Our ref:DOC25/424290

Your ref: SSD-84365208

Request for SEARs – Puggoon Solar Farm and Battery Energy Storage System

I refer to your request via the NSW Planning Portal dated 27 May 2025 seeking the Conservation Programs, Heritage and Regulation Group (CPHR) of the NSW Department of Climate Change, Energy, the Environment and Water (NSW DCCEEW) input into the Department of Planning, Housing and Infrastructure (DPHI) Secretary's Environmental Assessment Requirements (SEARs) for the preparation of an Environmental Impact Statement (EIS) for the Puggoon Solar Farm and Battery Energy Storage System (BESS) (SSD-84365208).

2.1 -Location Map

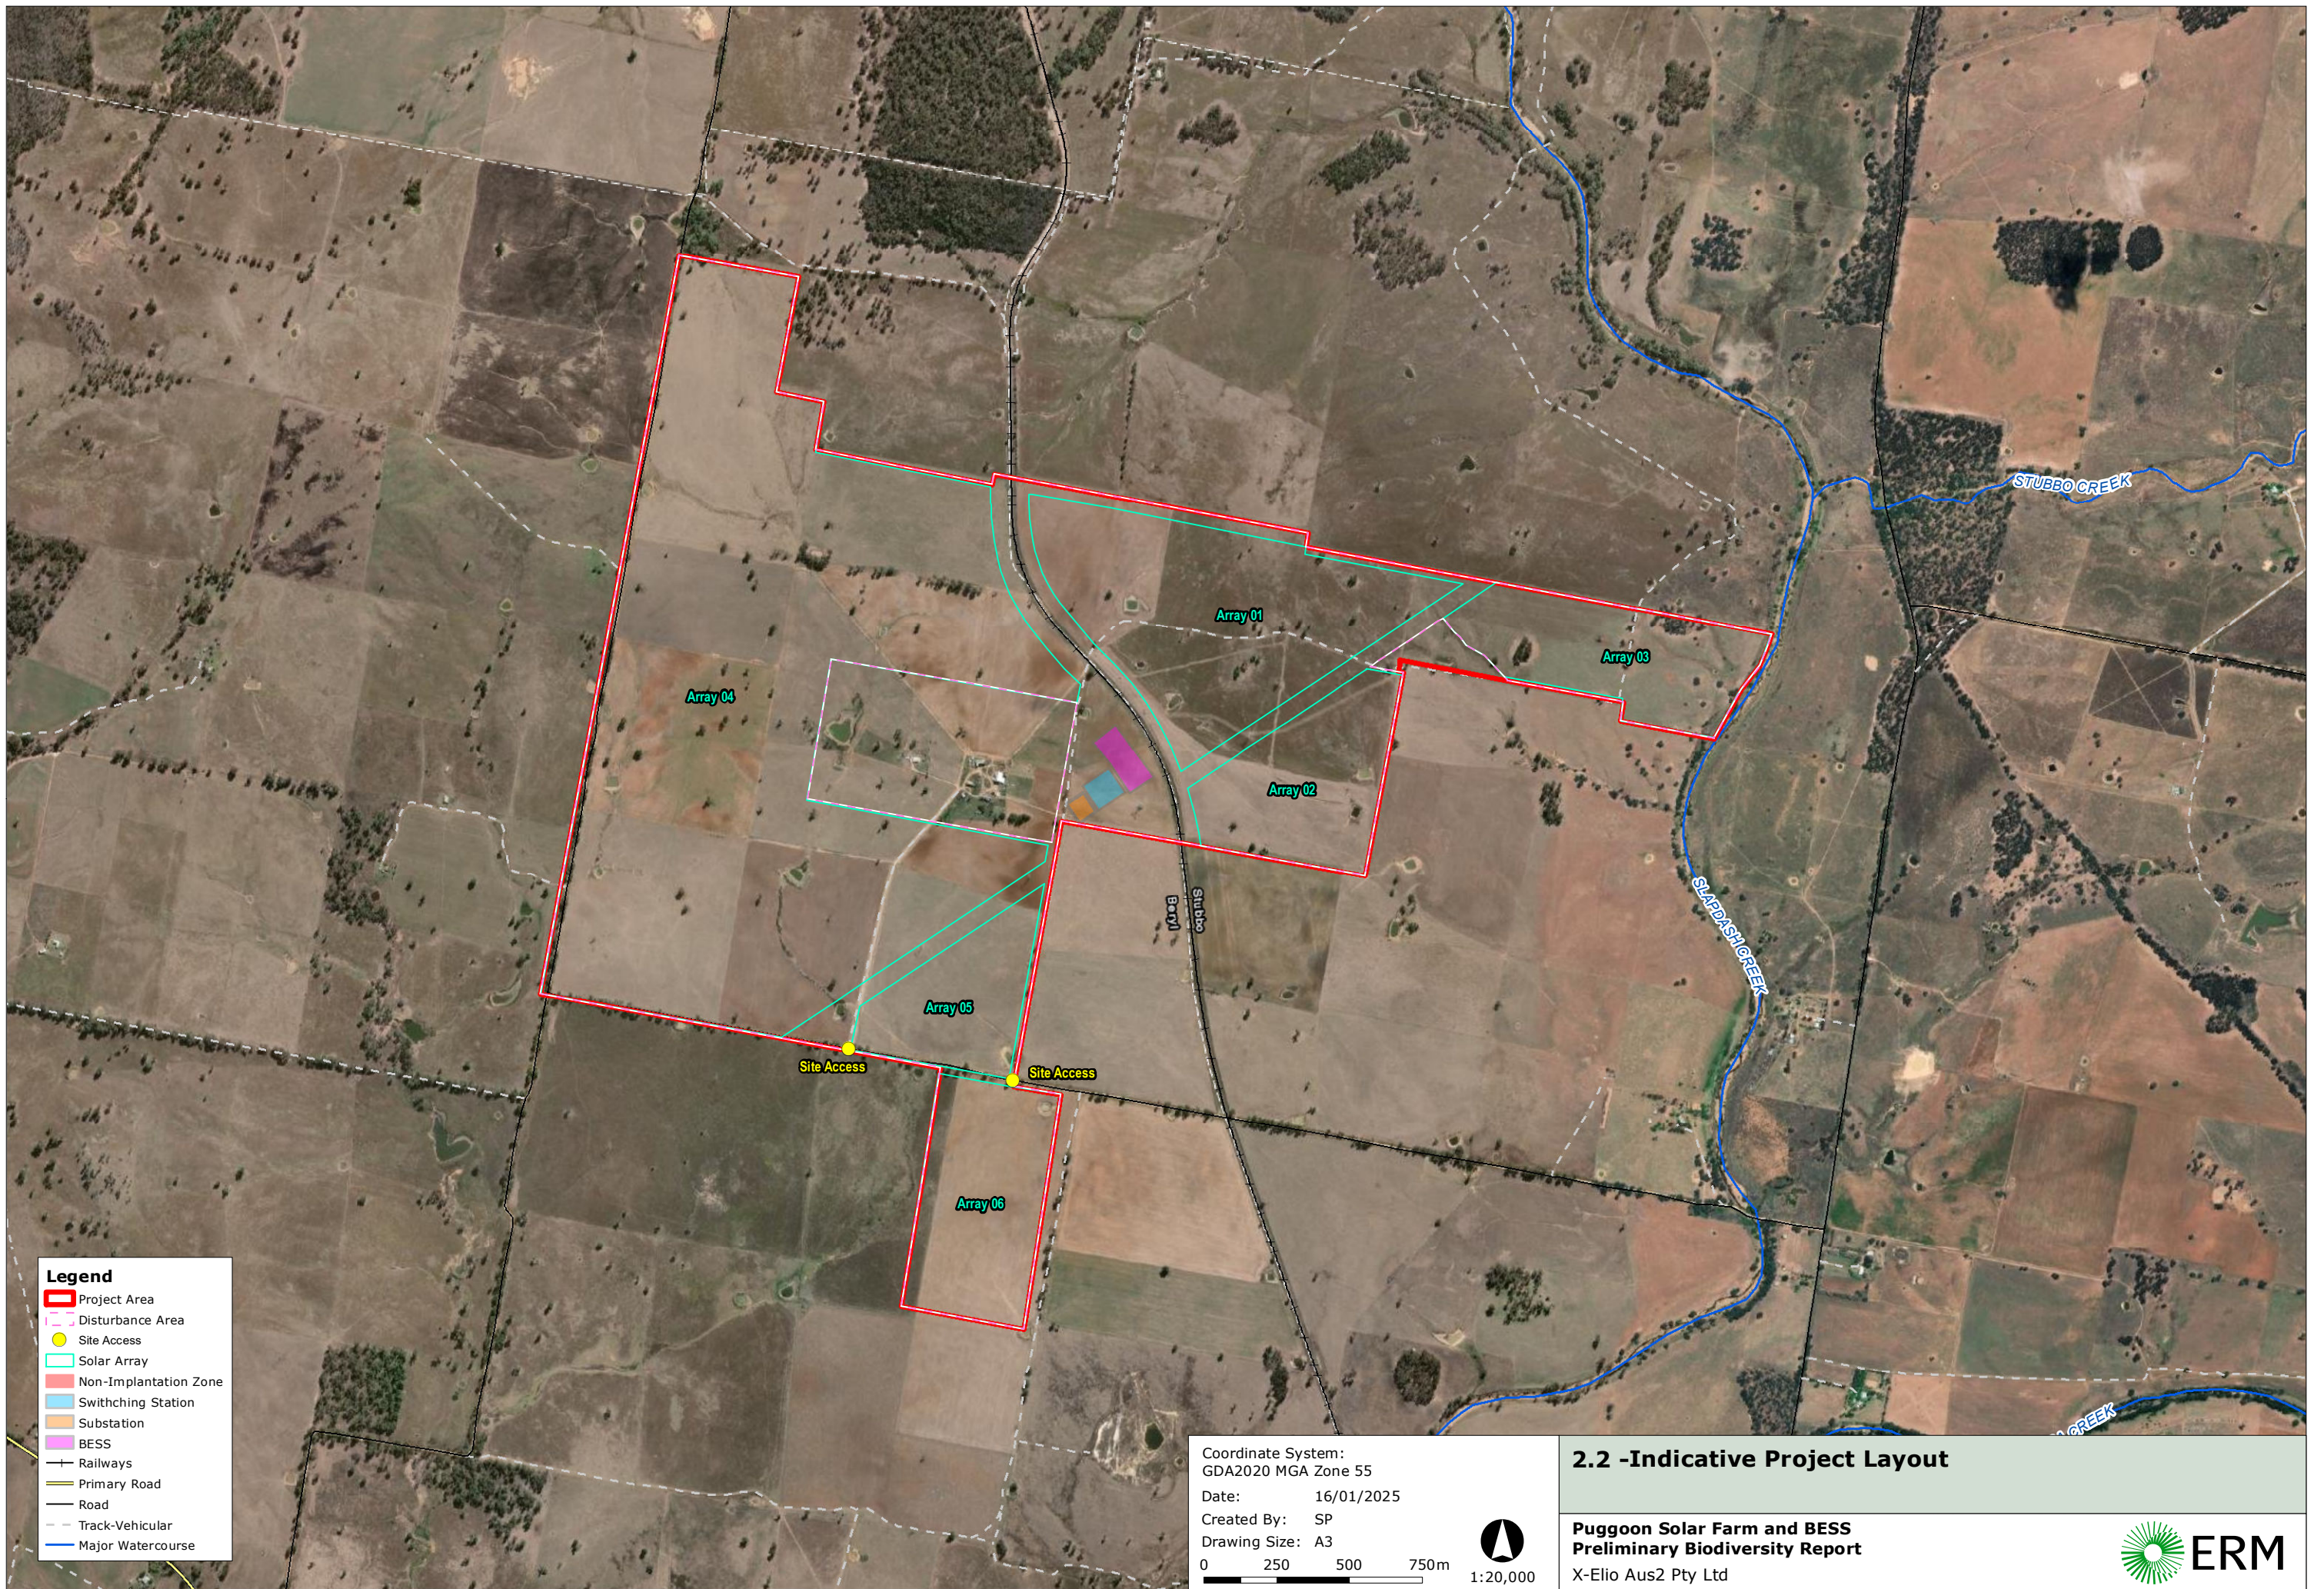
Furthermore, the assessment area does not appear to include all areas of native ground cover and tree canopy cover (including scattered trees). As outlined in Table 3-2 of the PBR, the current native vegetation extent is estimated to be 9.04%. Review of the current native vegetation extent mapping in Figure 2.1 of the PBR shows there are remnant trees which must be manually included in the mapping as per section 4.1.1 of the BAM. Including areas of native ground cover can be informed by additional mapping resources and by providing adequate justification for mapping areas as not native, as outlined in section 4.1.2 of the BAM.

8. Reassess the native vegetation extent within the assessment area and include all areas of native vegetation, ensuring this extends to native ground cover and tree canopy cover (including scattered trees) as outlined in section 4.1 of the BAM (2020).

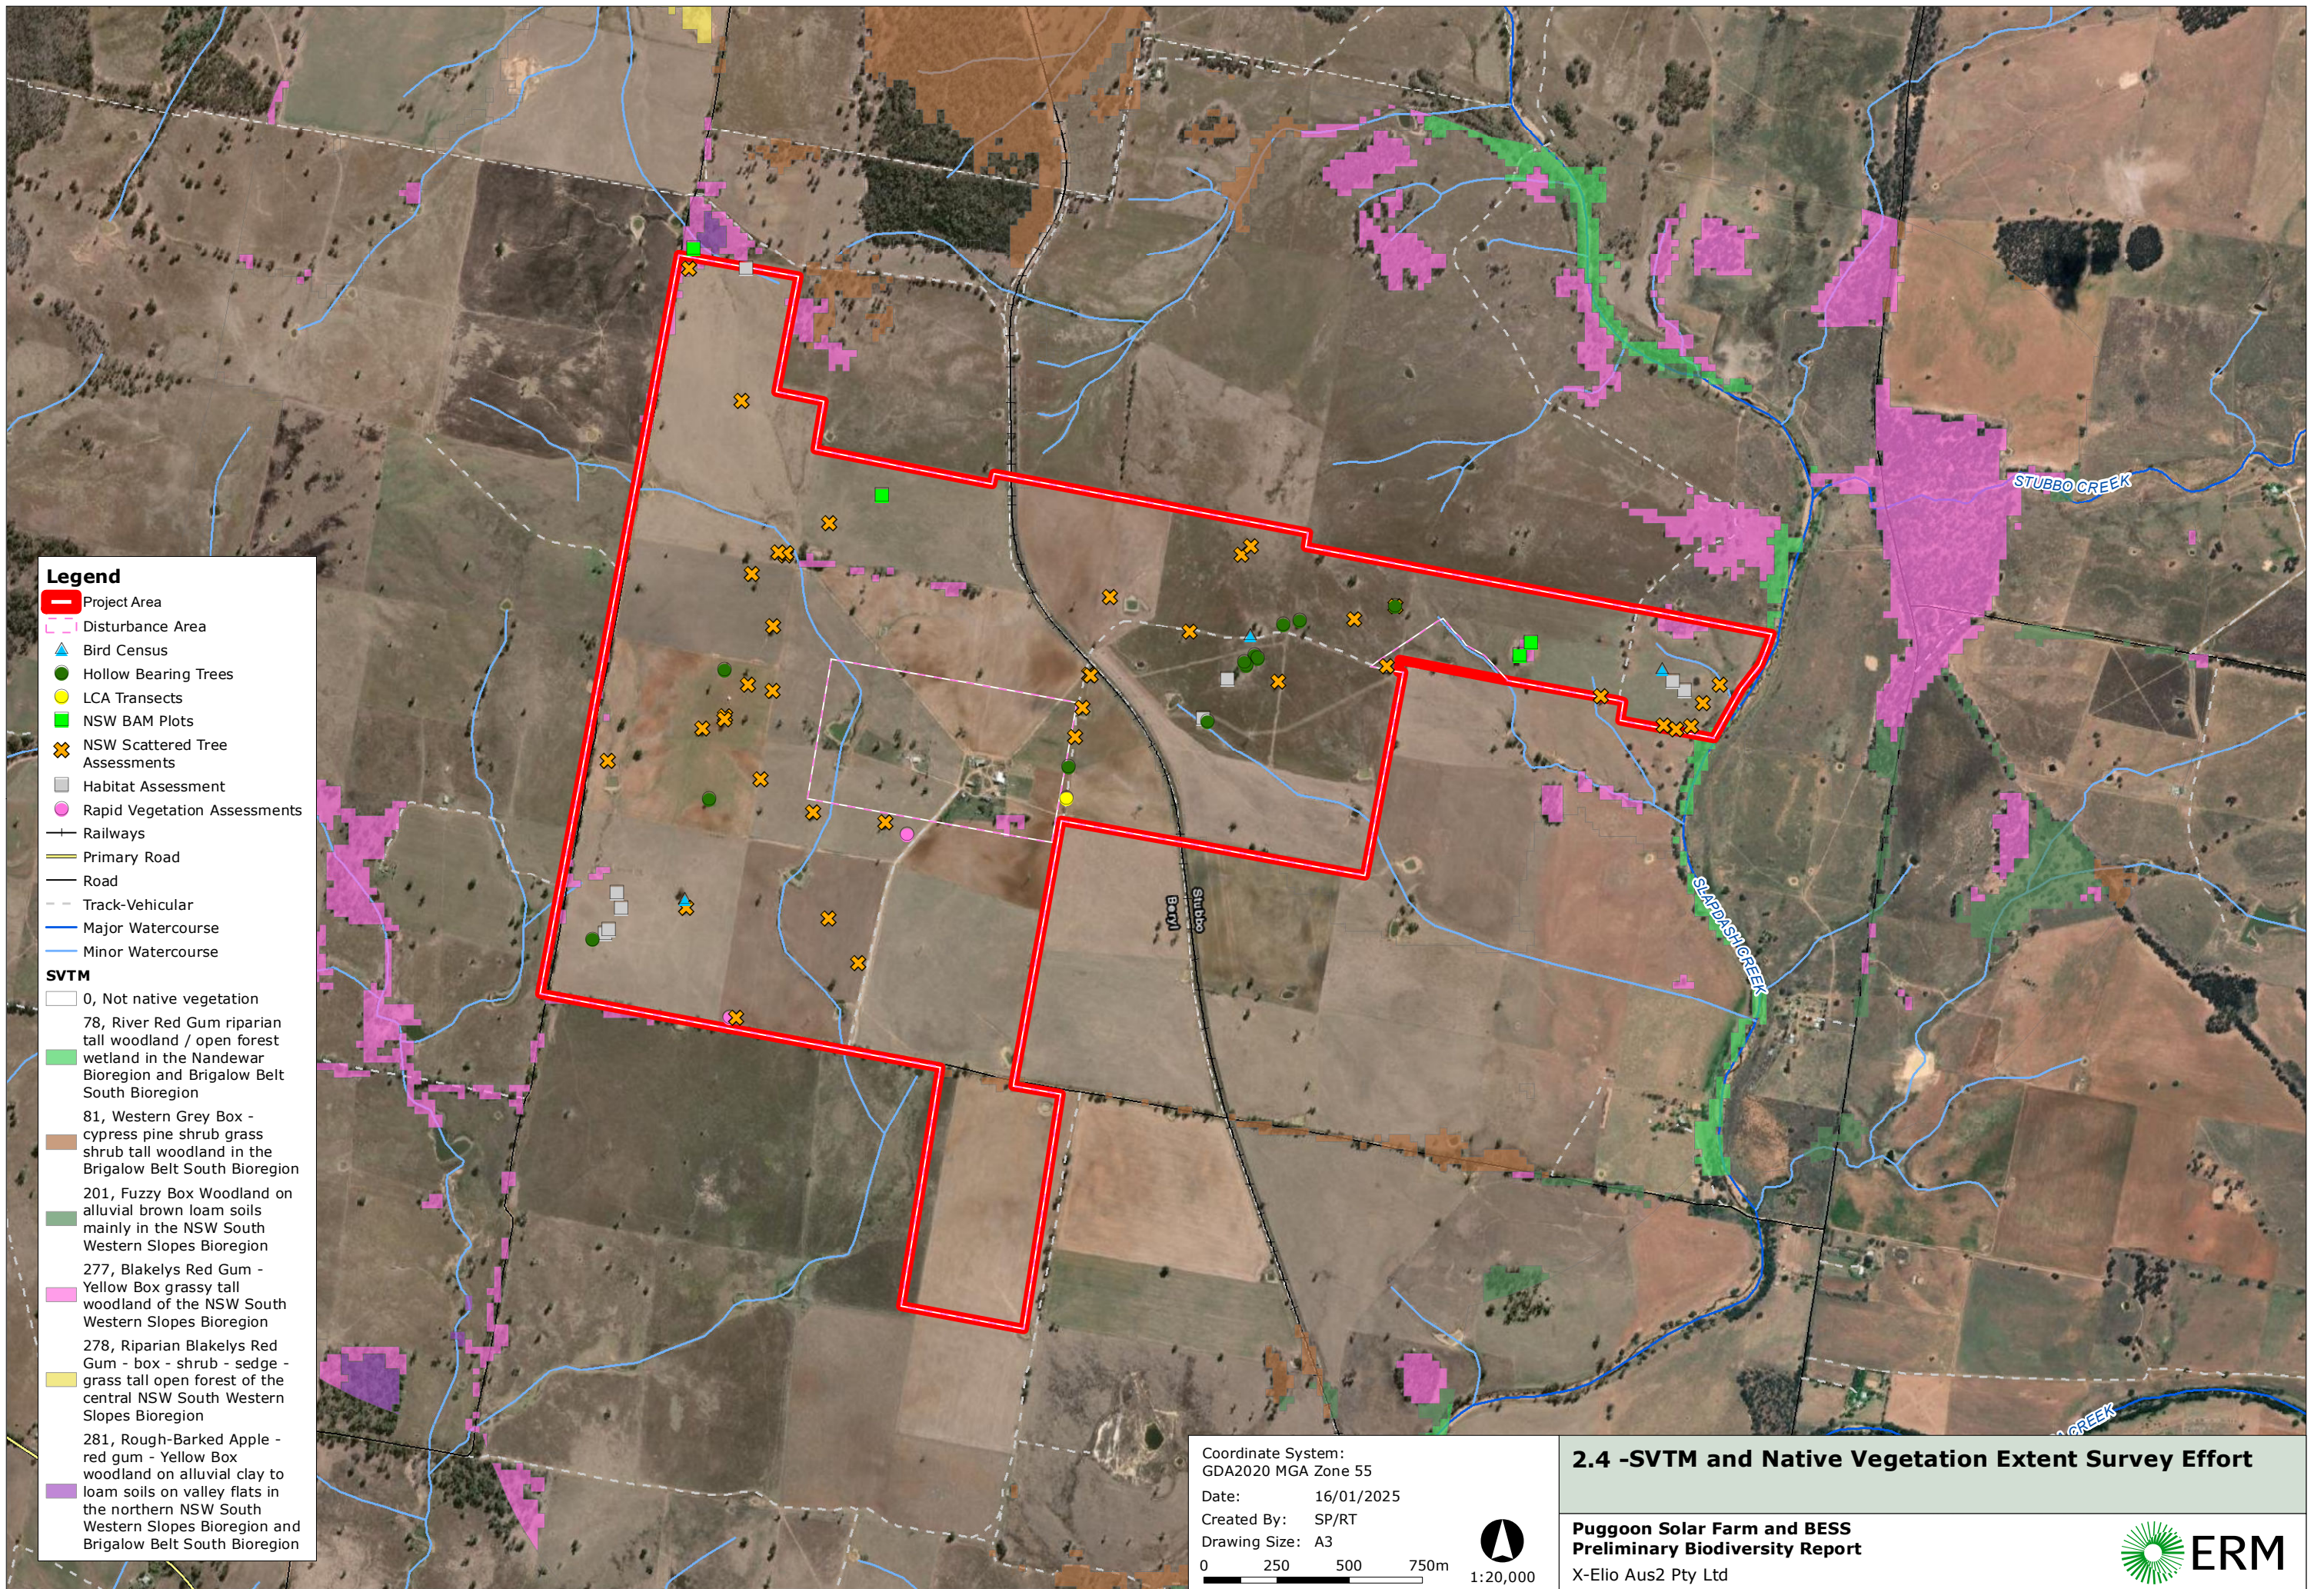
- It is indicated that a Land Category Assessment (LCA) report will be submitted in support of the BDAR. Based on Figure 4-1 of the PBR, this appears to include review and reclassification of an area mapped as Category 2 – Regulated land on the draft Native Vegetation Regulatory Map (NVR Map) to Category 1 – Exempt land. There is potential for that land to contain White Box – Yellow Box – Blakely's Red Gum Grassy Woodland and Derived Native Grassland (Box Gum Woodland), a critically endangered ecological community (CEEC) at risk of serious and irreversible impact (SAIL). Box Gum Woodland CEEC must be mapped as Category 2 – Sensitive Regulated land.

We note that portions of the development site are mapped as Category 2 – Regulated land on the draft Native Vegetation Regulatory Map (NVR Map) (as shown in Figure 2.3 of the PBR). Preliminary mapping in Figure 4-1 of the PBR suggests that much of the site may be mapped by the assessor as ‘non-native’ (stated on page 19 as depicting proposed Category 1- Exempt land), including some areas of draft NVR Map Category 2 - Regulated land.

1. Investigate all areas of the subject land for the presence of CEECs or critically endangered plants regardless of the land categorisation on the draft NVR map. When determining the extent of CEEC DNG, assessment of ground cover should be made during the time of year when the proportion of native ground cover on the subject land is likely to be at its maximum compared to that of exotic ground cover. Land containing CEECs (including DNG) must be mapped as Category 2 – Regulated land.

2. Provide evidence in the land category assessment which demonstrates that CEECs and critically endangered plants have been adequately considered in areas of Category 1 – Exempt land.
